Department of Transportation

January 24, 2020

RE: Pearson's Ministries - dba Legacy Church - Hydraulics and Site Development
Plan_PPR1933

5-Year **Engineering Profile - EXISTING STORM (REROUTED) (Green Mountain Falls Church_StormCAD.stsw)**

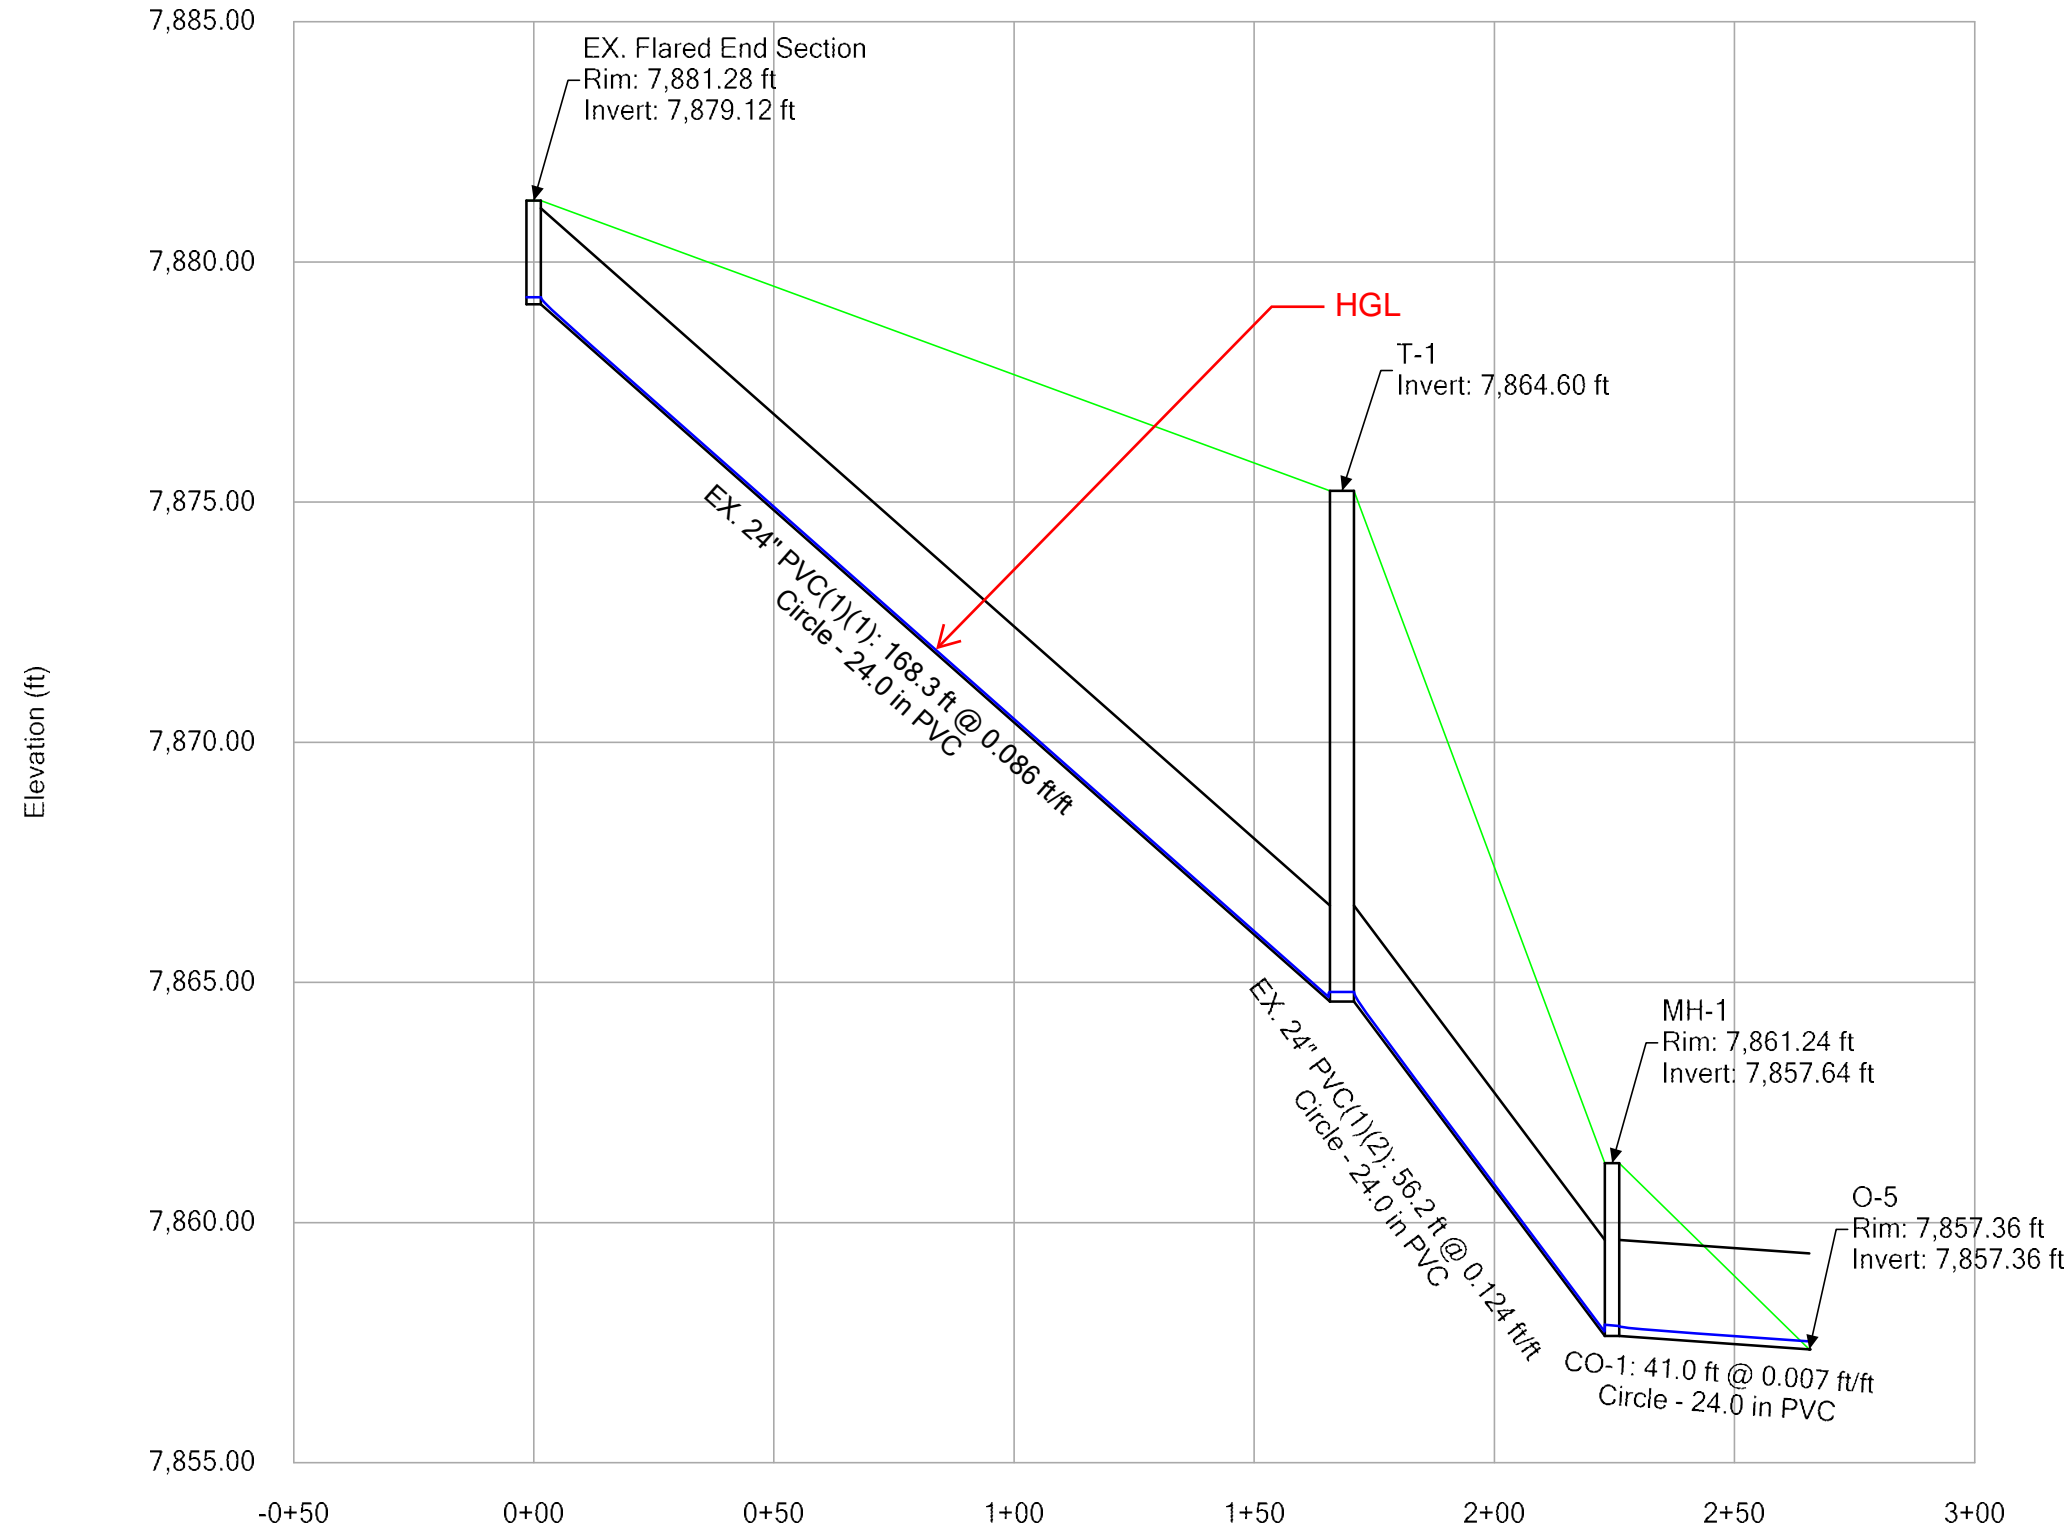
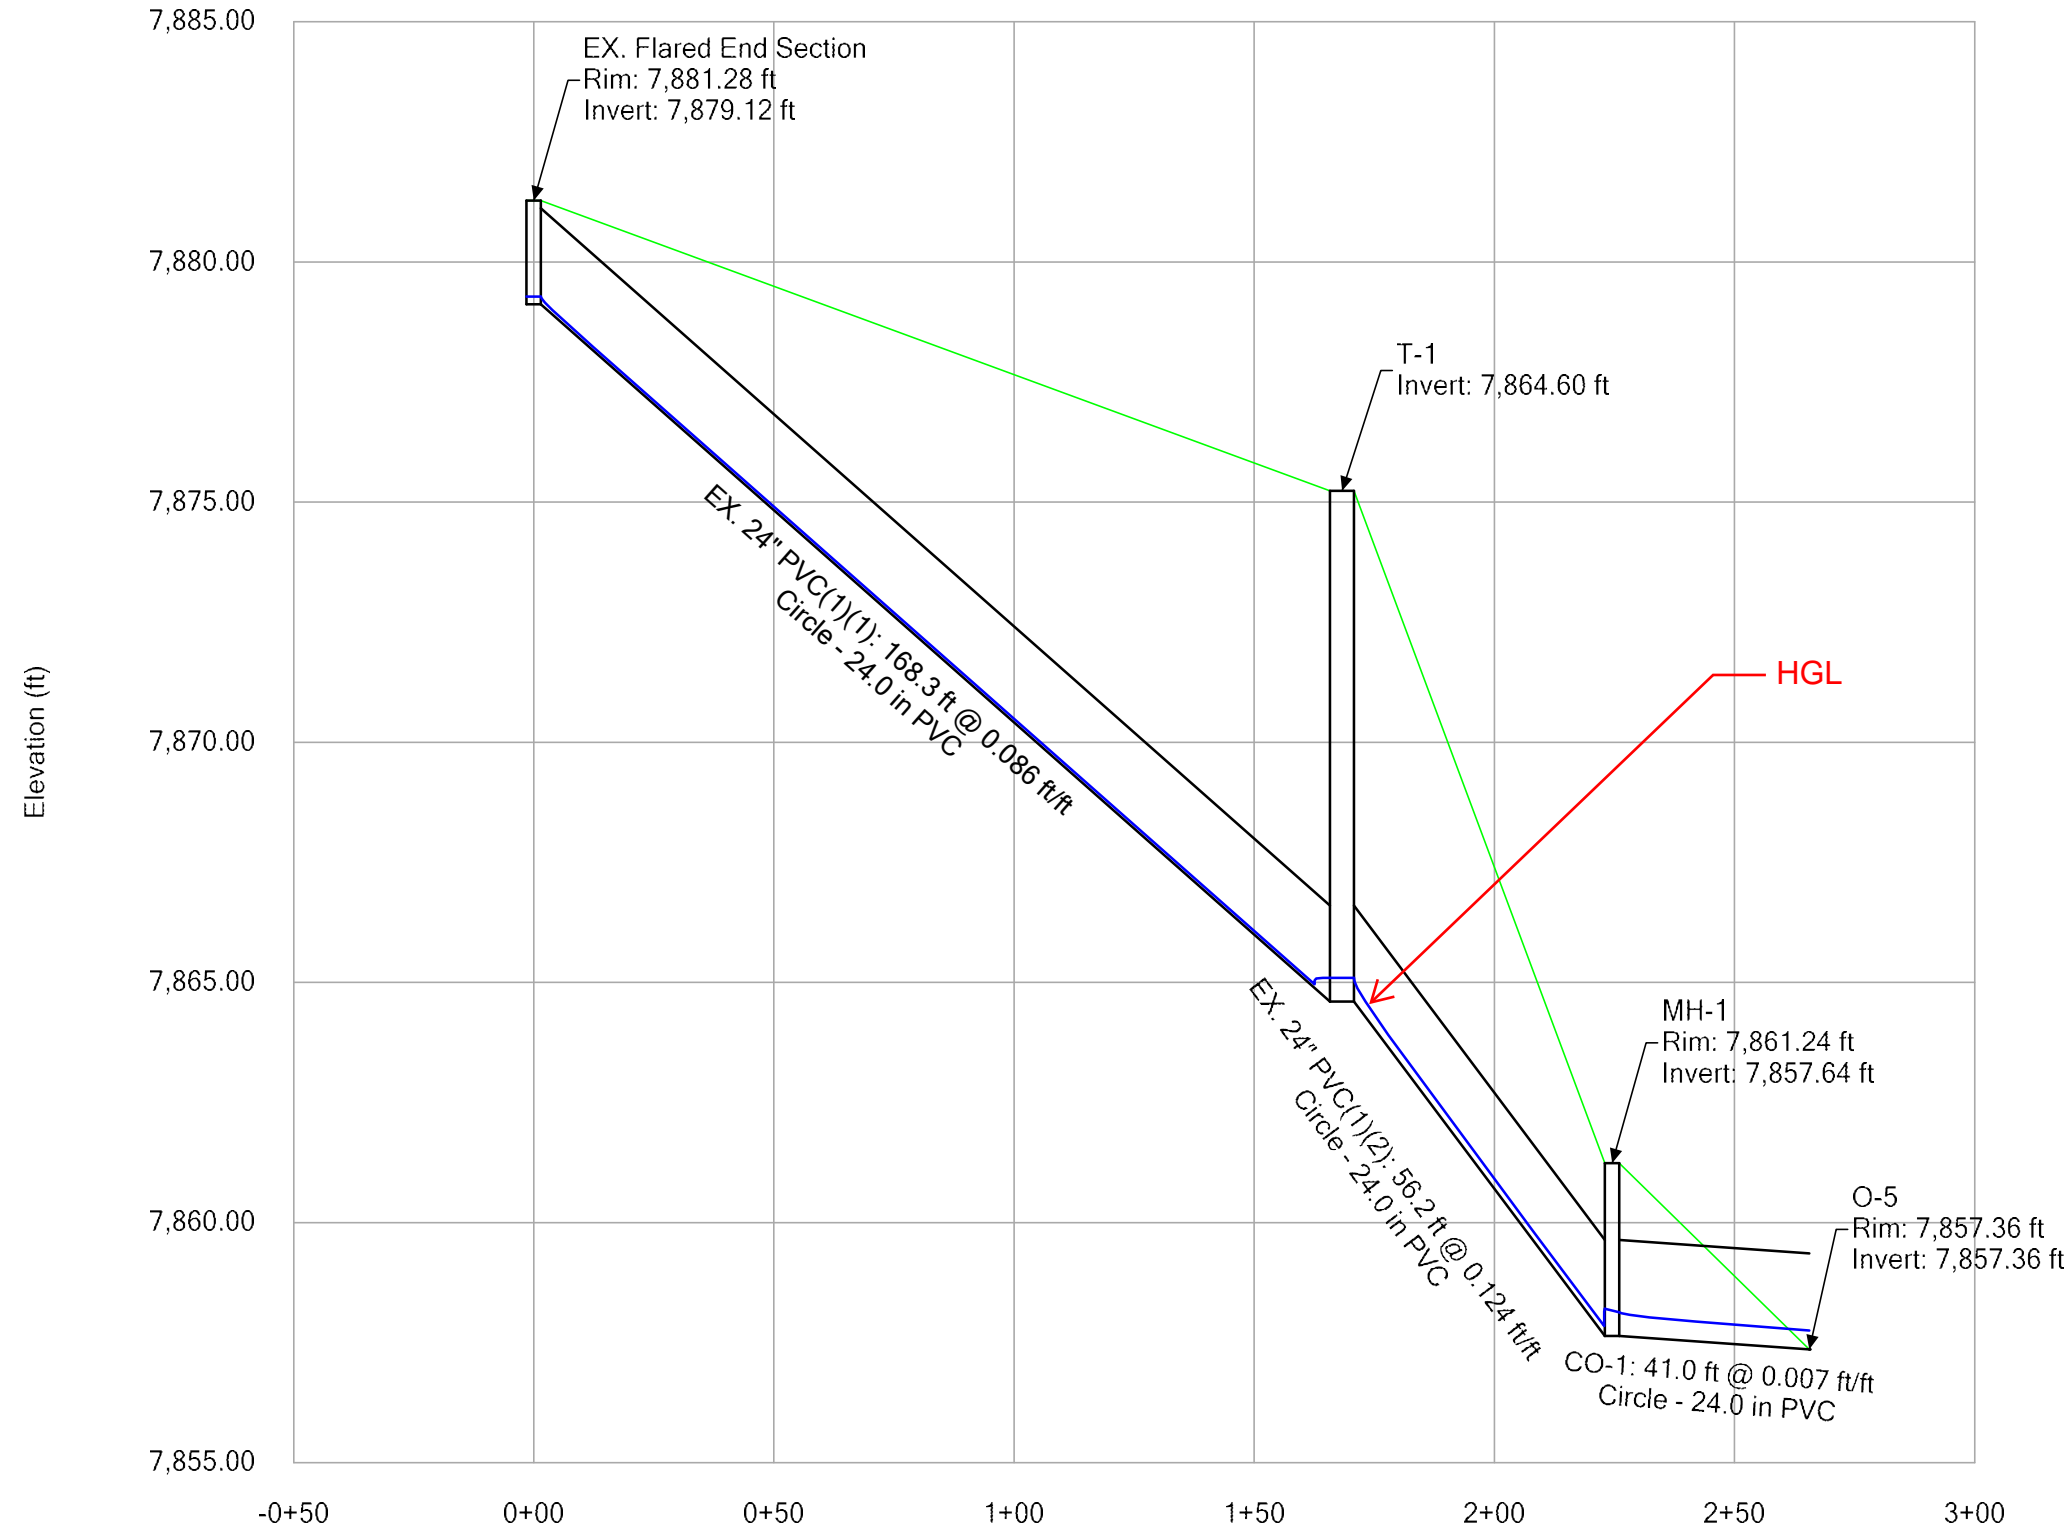
- c. Existing 24" pipe draining to the southwest is shown connecting to a pipe that appears to be proposed by this project, sheet 4. Details are missing, please provide.
